From: Joyce Christie
Sent: 18 March 2022 17:03
To: James Kirkham
Subject: 22/00256/F North Arms Wroxton

Brief comments as promised. Please let me know if you need anything more before I upload this to DEF

GROUND FLOOR

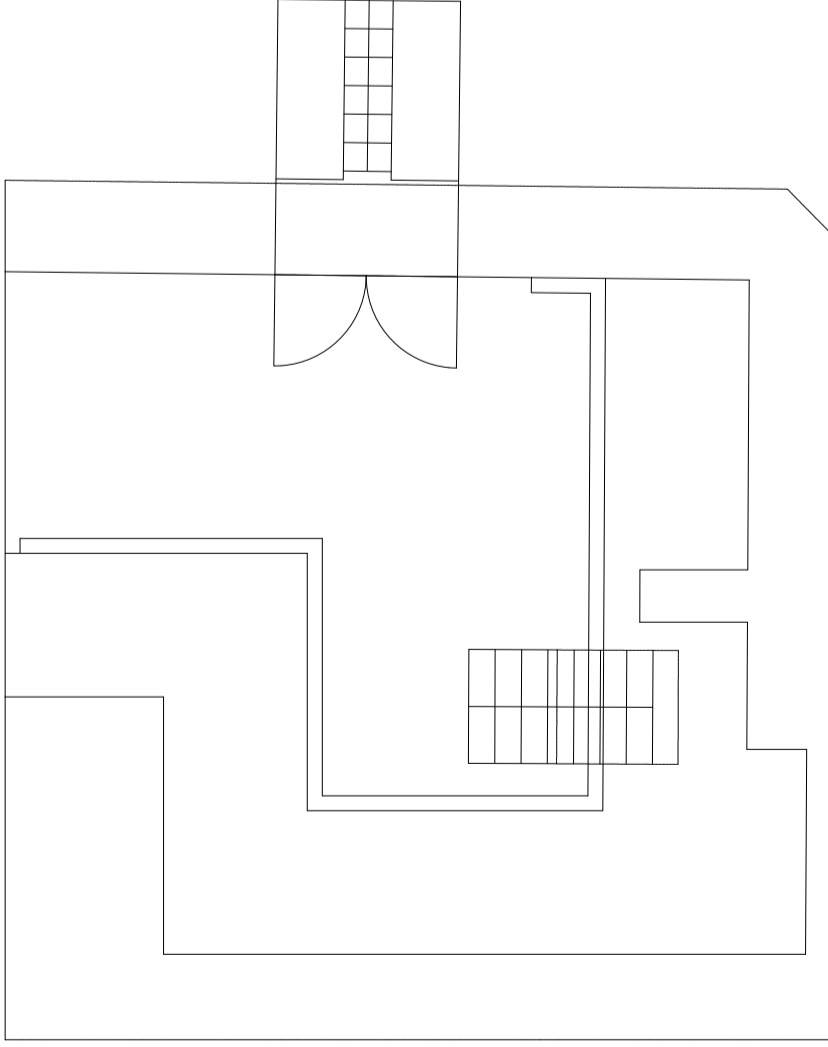
Q. Is there a corresponding application for Listed Building Consent to cover the minor changes to the ground and first floor?

Ground floor – removal of sink, removal of toilets and insertion of new toilet/removal of bar and installation of kitchen.

FIRST FLOOR

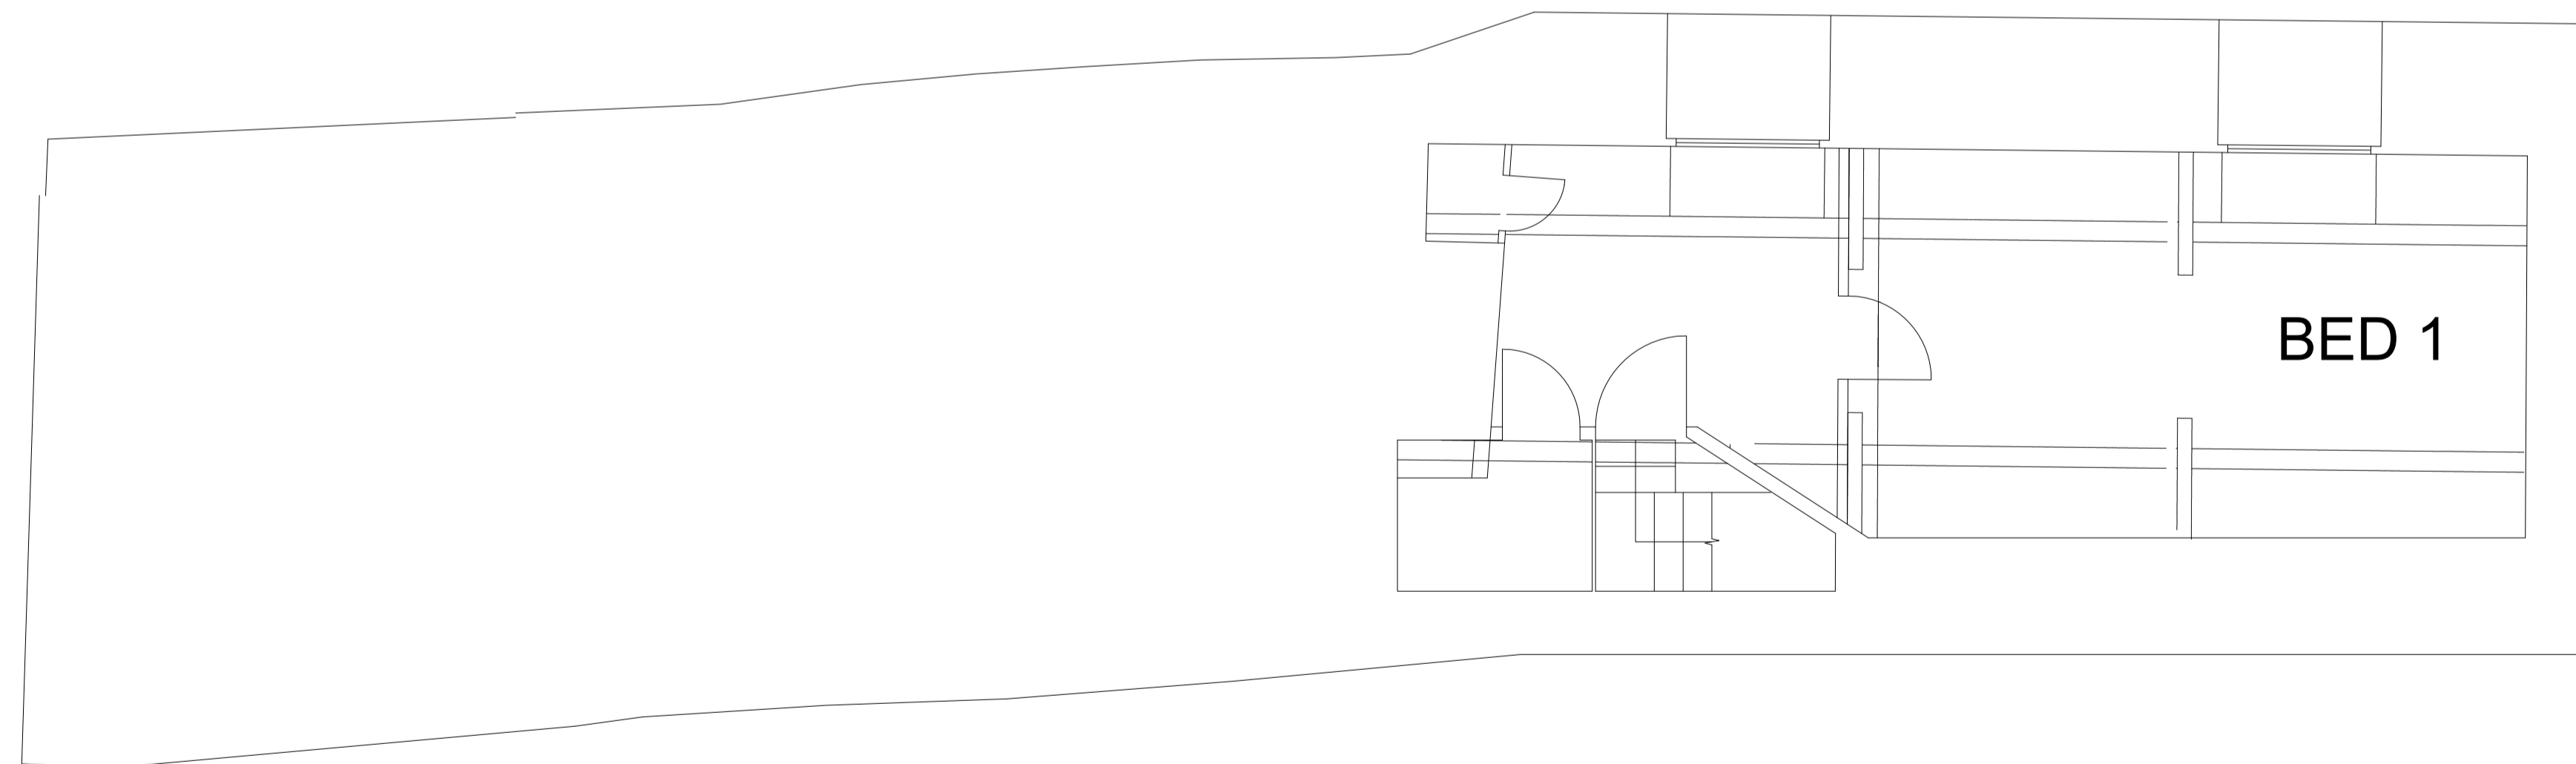
First Floor – removal of partitions to form bedroom 4
